<b>Application Ref:</b>	2025/0803			 <b>Ribble Valley Borough Council</b> <small>www.ribblevalley.gov.uk</small>				
<b>Date Inspected:</b>	16/10/2025	<b>Site Notice:</b>	16/10/2025					
<b>Officer:</b>	EP							
<b>DELEGATED ITEM FILE REPORT:</b>					<b>APPROVAL</b>

<b>Development Description:</b>	Proposed single storey rear and side extension.
<b>Site Address/Location:</b>	Ringley Hey Slaidburn Road Waddington BB7 3JJ.

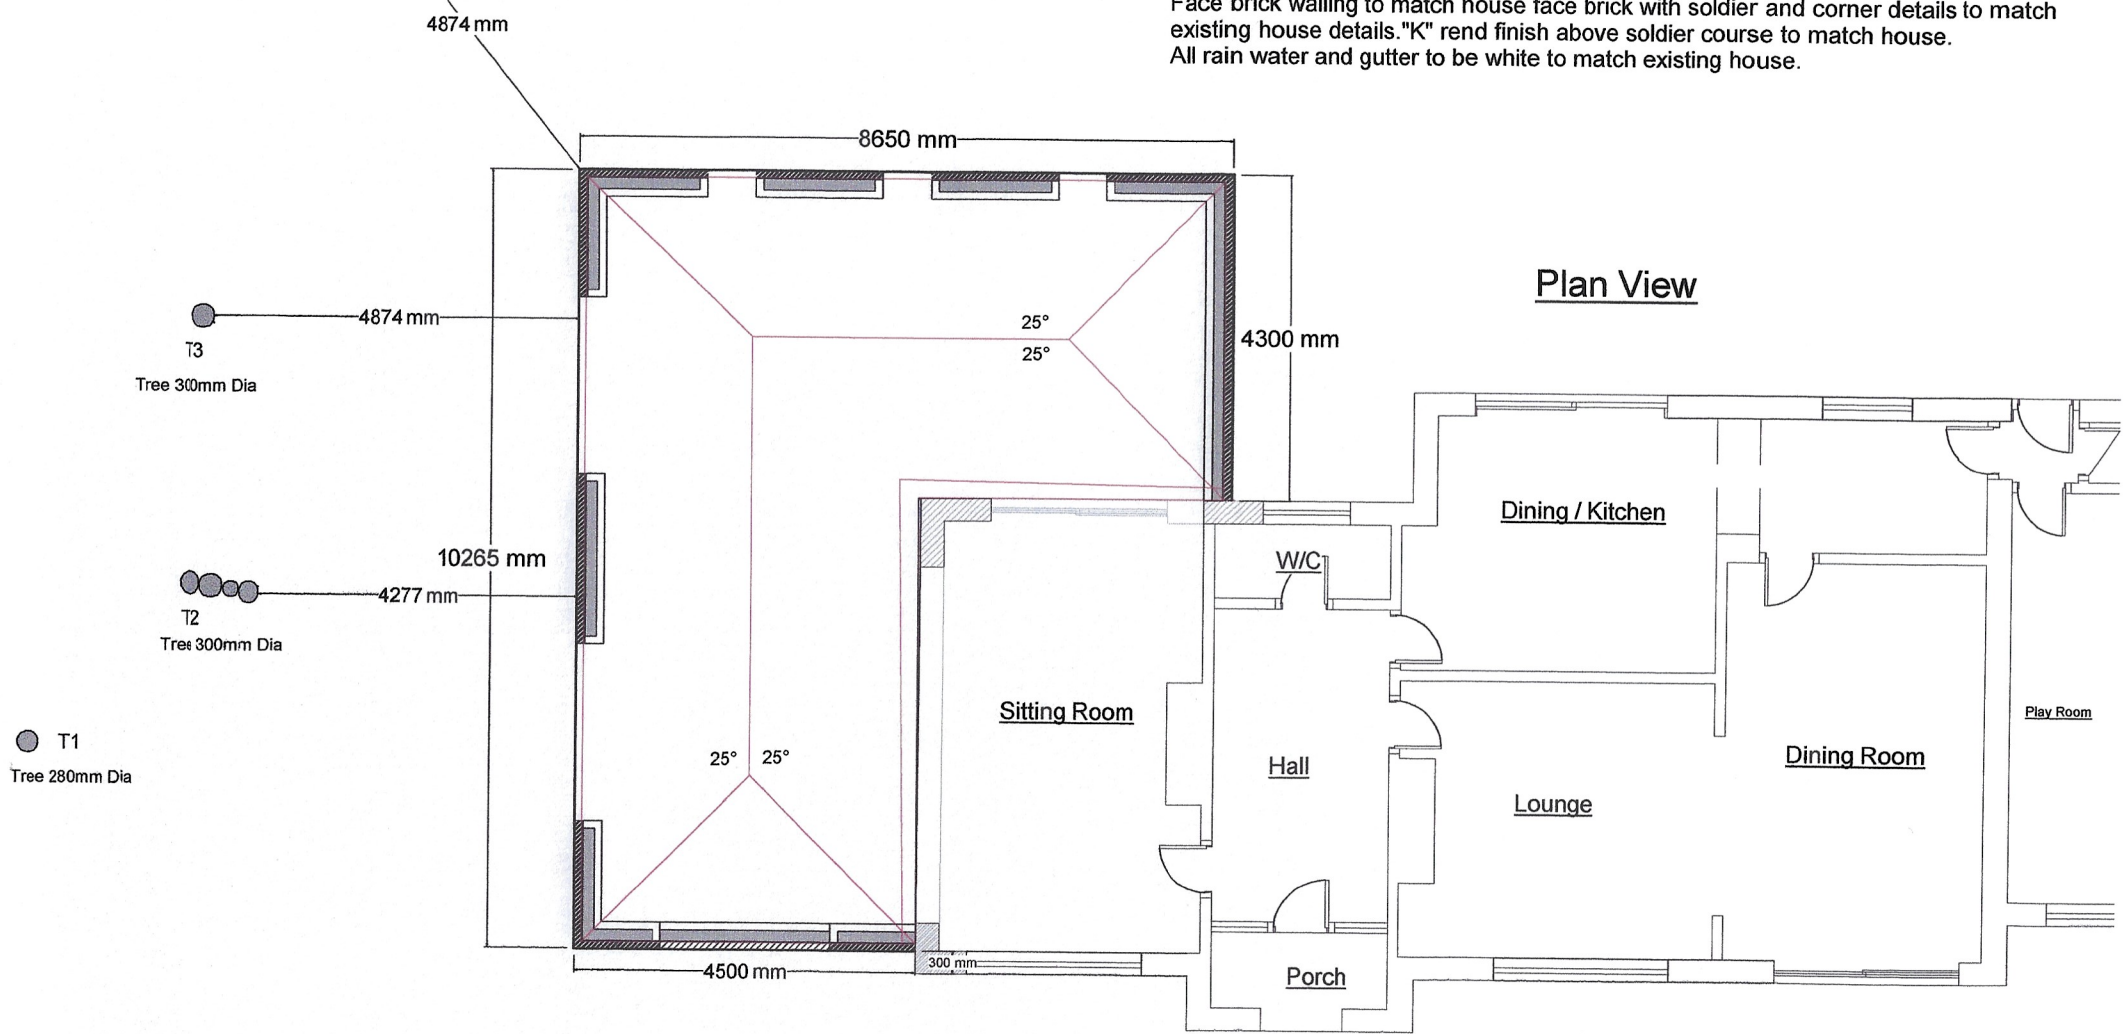
Consent is sought for the construction of a single storey wrap around extension located to the northwestern extents of the application dwelling. The extension will feature a pitched roof profile and will comprise an 'L' shaped footprint accommodating extended living space. Amended plans have been received reducing the width of the extension, introducing a small-set-back, omitting the rooflights and re-positioning a window on the side elevation.

The proposed extension will comprise an 'L' shaped configuration measuring 10.3m and 8.7m in length and width at its greatest points. Whilst the overall footprint of the extension is substantial, it is relative to the scale of the host dwelling and will not result in the creation of an over dominant addition. The roof profile is pitched measuring 2.7m and 3.9m to the eaves and ridge respectively (measured from the highest ground point, which is substantially shorter than the existing dwelling. As a result, the extension will take an entirely subservient position to the host dwelling.

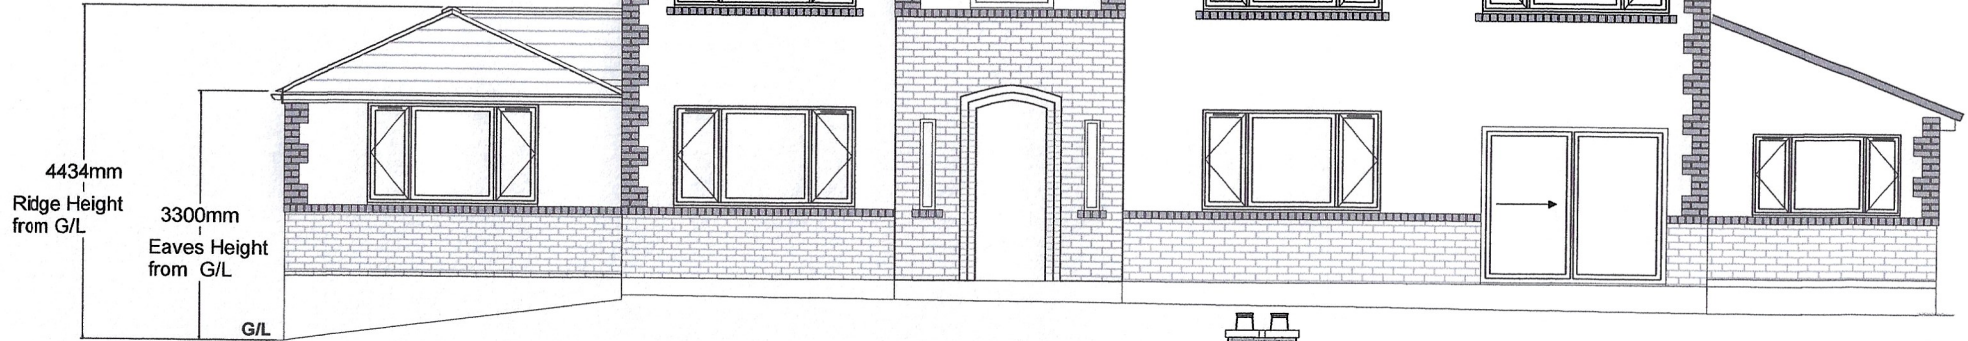
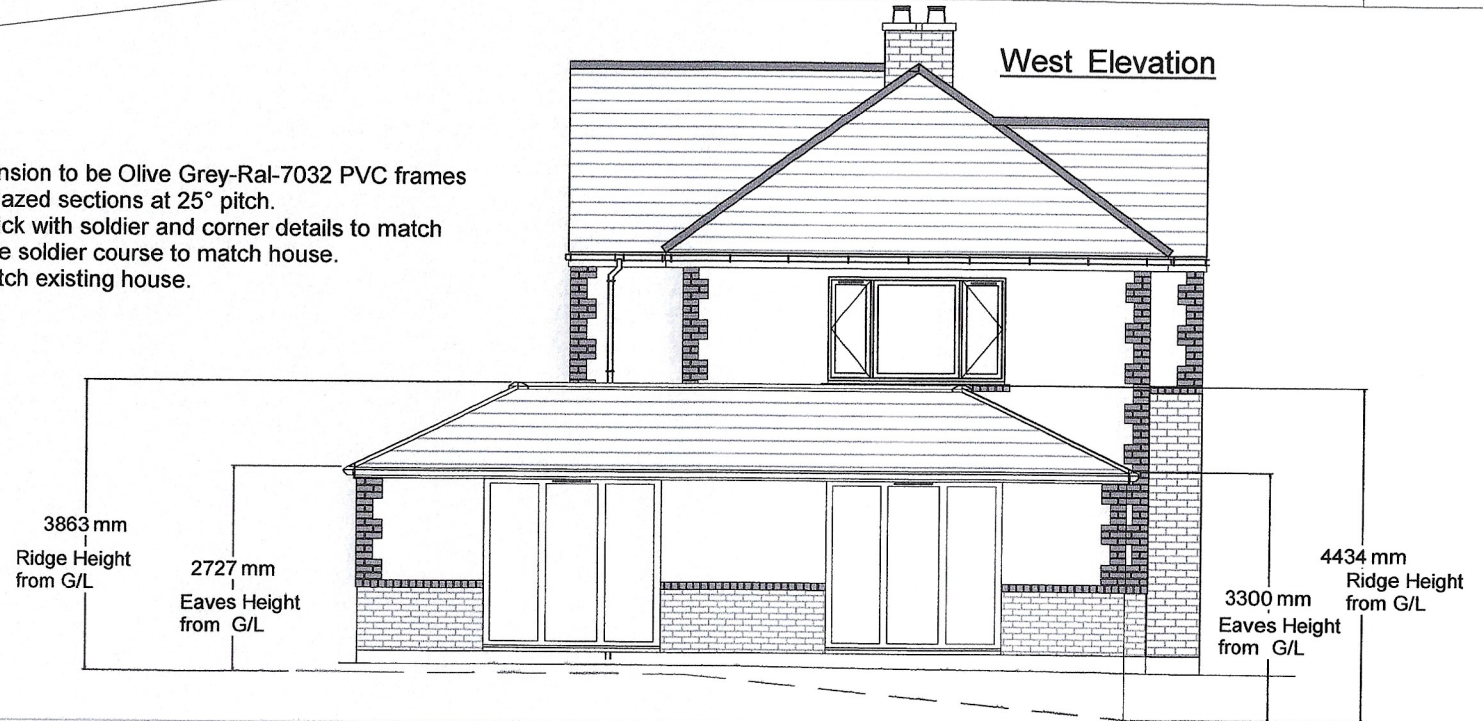
In respect of materials, the extension will be constructed in facing brick and render to the elevations, with uPVC windows and composite rooftiles. These materials are consistent with the existing dwelling and as such the development will integrate sufficiently into the site.
